Response to Newcastle City Council's Submission

RE: Response to Submission from Newcastle City Council on Mixed Use Development (SSD 8440) at 42 Honeysuckle Drive, Newcastle NSW 2300

Scale	1:150	@ A1	1:300 @ A3
Drawn	MDJ	Checked	VG
Project no.	s12109		
Status	DA		
Plot Date	27/09/2017 6:06:15 PM		
Plot File	\\lv-vfp-01\home\JDM\Documents\42HONEYSUCKLEDRIVE_BS_ARCH_DA_JDM.rvt		
Drawing no.	A03.101	Revision	A

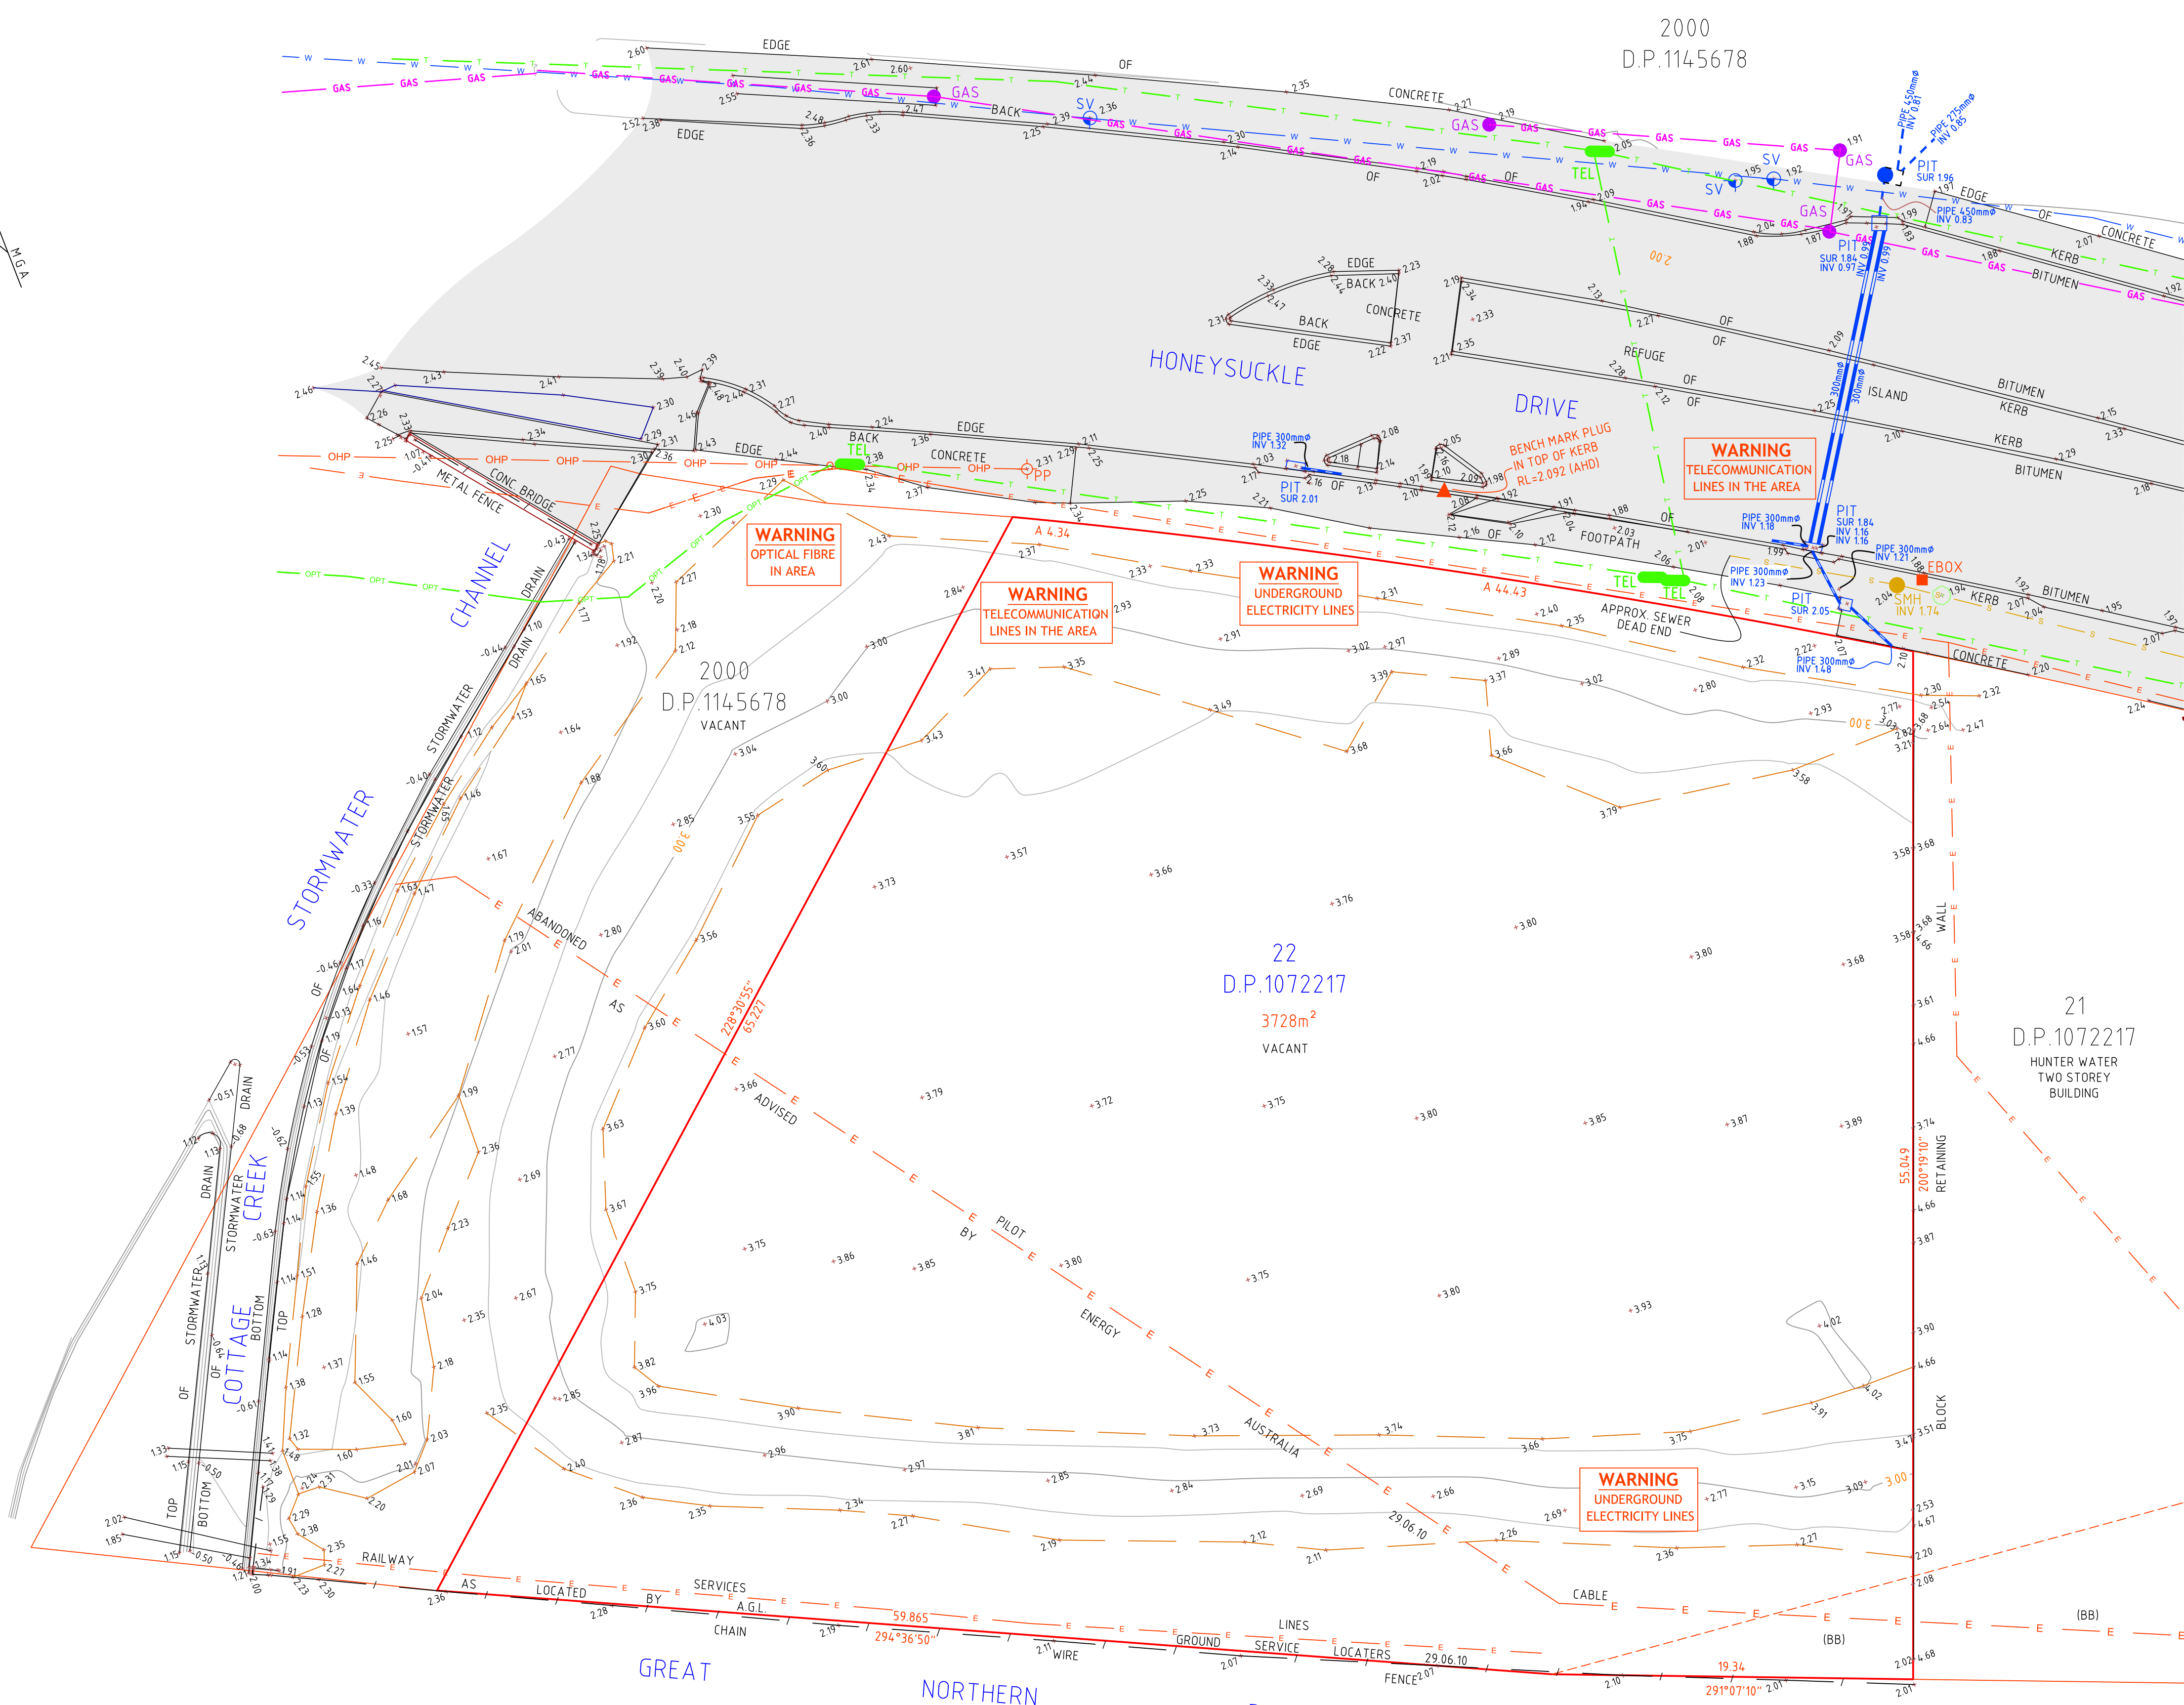
The majority of the ground floor slab, with the exception of the southern parking area, is set at 3.0m AHD rather than 2.9m AHD.

Lift 'P' opens only into the public entry area and not into the residential lobby. Both of these lobbies have also been set at 3.0m AHD.

The pump room that was located on ground level has now been relocated to the rooftop.

- a) *The proposed hotel drop-off on Honeysuckle Drive is not supported as it removed four kerbside parking spaces. Accordingly, the proposed drop off area will need to be relocated on site.*

- c) *The submitted plans do not clearly identify the visitor parking for the residential units, the allocation of parking for the retail unit, hotel parking, public parking and staff parking.*

- d) *It is not clear from the submitted plans as to whether the development will include roller gates or boom gates and ticket booths for the driveway. If such a facility is proposed, it would need to be designed to provide on-site queue distance for two vehicles, while also allowing clear sightlines for vehicles exiting the site.*

- g) *The 'public car park entry' from Honeysuckle Drive frontage will need to be separated from the exit driveway to mitigate the potential for pedestrian/vehicular conflict. Details required.*

- h) *The development has not included bicycle parking storage for hotel guest in accordance with the relevant requirements of the Newcastle Development Control Plan 2012.*

The proposed hotel drop-off has been addressed in section 3 of the response to the Department's letter. To briefly summarise, the carparking spaces are not proposed to be removed for the hotel drop-off. The spaces will remain and will be a short term parking spaces such as 5 or 15 minutes.

The latest iteration of plans indicates which spaces are designed for retail, hotel and resident parking.

Neither roller doors or boom gates are intended to be installed. Licence plate recognition will be the likely mechanism to registering of vehicles entering the site. This will negate any possible queueing onto the site as there will be no restriction to the flow of traffic by means of a boom gate or roller door. This will also mean that there will be no sightline concerns for vehicles exiting the carpark.

A 1m median is provided separating the entry and exit lanes to the carpark (this is shown on the amended floor plan). The total driveway crossover width of 7.8m allows sufficient room for two vehicles to pass on the footpath crossover while leaving sufficient room, if need be, for pedestrians to refuge between entering and exiting vehicles.

Plans have been amended to include a hotel guest bicycle parking storage area.
